CITY OF ALBUQUERQUE

December 6, 2022

Re: Dollar General
7500 Universe Blvd. NE
Traffic Circulation Layout
Engineer's/Architect's Stamp XX-XX-XX (C09-D017)

AS-1

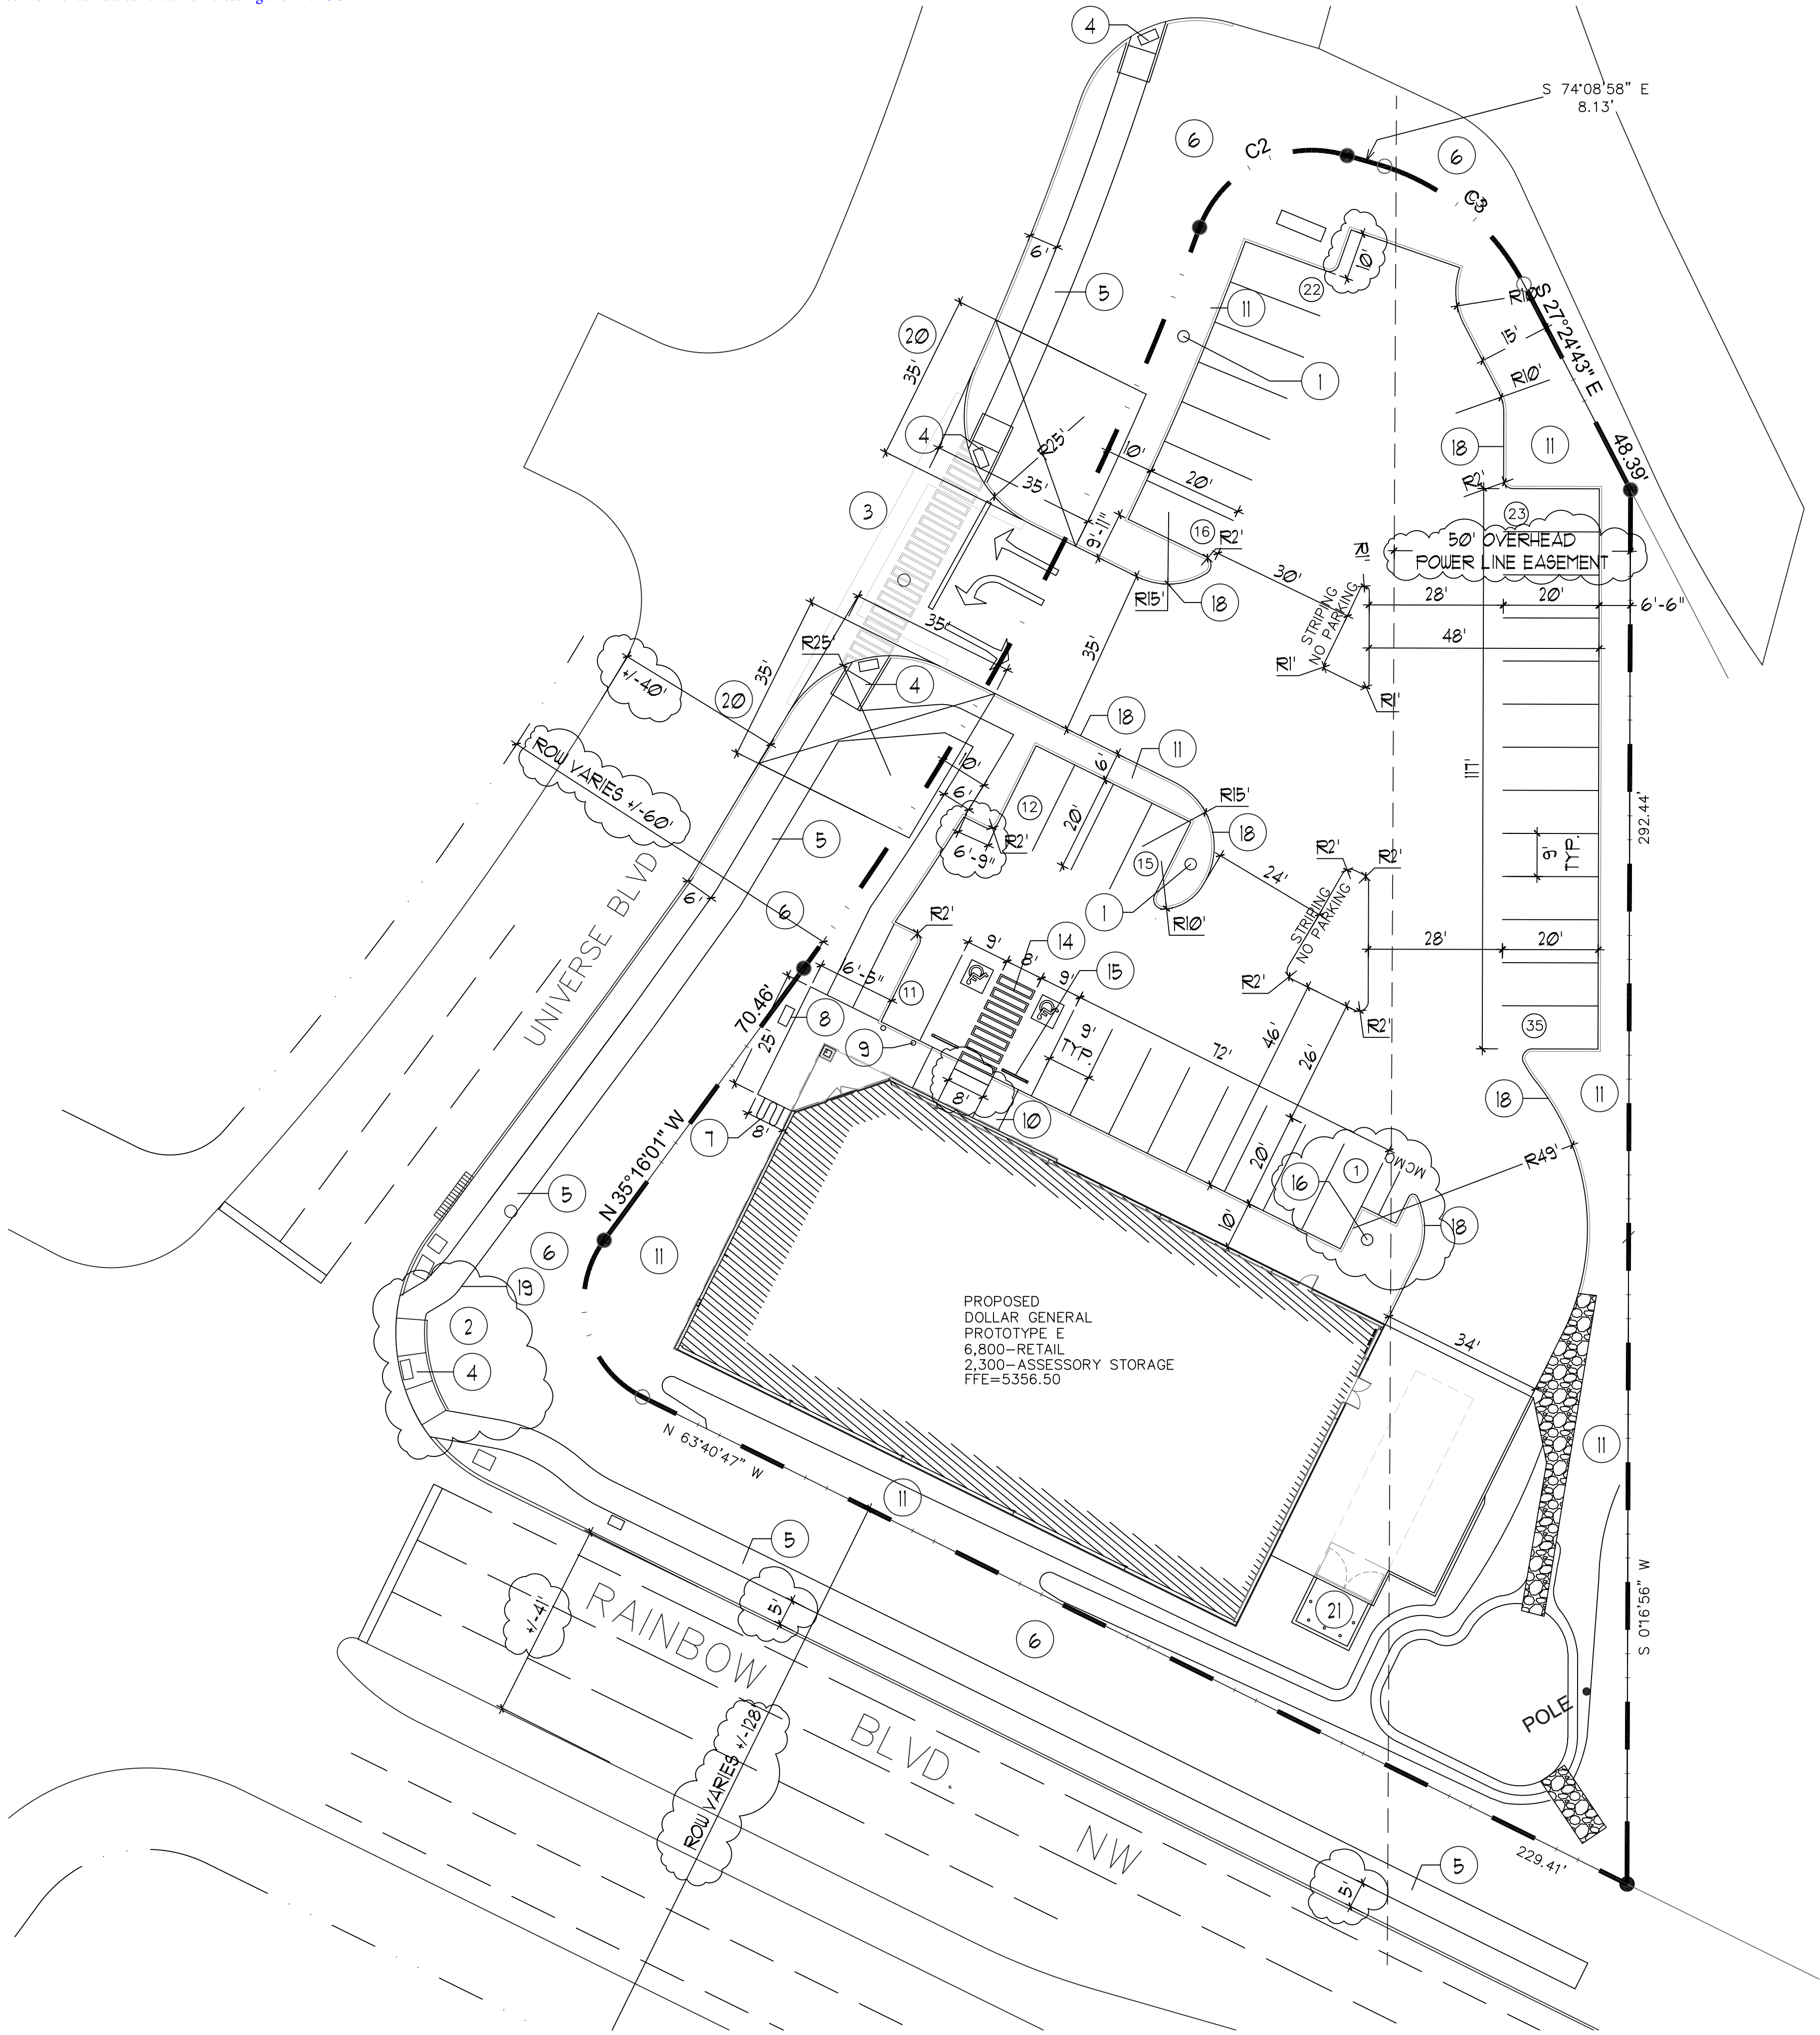
1. The traffic circulation layout must be stamped, signed, and dated by an engineer or architect licensed in the state of New Mexico.
2. Identify all existing access easements and rights of way width dimensions.

3. Identify the right of way width, medians, curb cuts, and street widths on Universe Blvd. and on Rainbow Blvd.
4. ADA curb ramp at the corner of Universe Blvd. and Rainbow Blvd. must be updated to current standards and have truncated domes installed.

5. Motorcycle parking spaces shall be designated by its own conspicuously posted upright sign, either free-standing or wall mounted per the zoning code.

6. The pavement marking "MC" should be shown in the opposite direction for motorcycles entering the parking space.
7. A 5 ft. keyway is required for dead-end parking aisles.

8. Please provide the ADA landing area dimension.
9. Please provide a copy of Fire Marshal and Solid Waste approval.
10. Show the clear sight triangle and add the following note to the plan: "Landscaping and signage will not interfere with clear sight requirements. Therefore, signs, walls, trees, and shrubbery between 3 and 8 feet tall (as measured from the gutter pan) will not be acceptable in the clear sight triangle.

11. Please specify the City Standard Drawing Number when applicable.
12. Work within the public right of way requires a work order with DRC approved plans.

13. Please add a note on the plan stating "All improvements located in the Right of Way must be included on the work order."
14. Please provide a letter of response for all comments given.
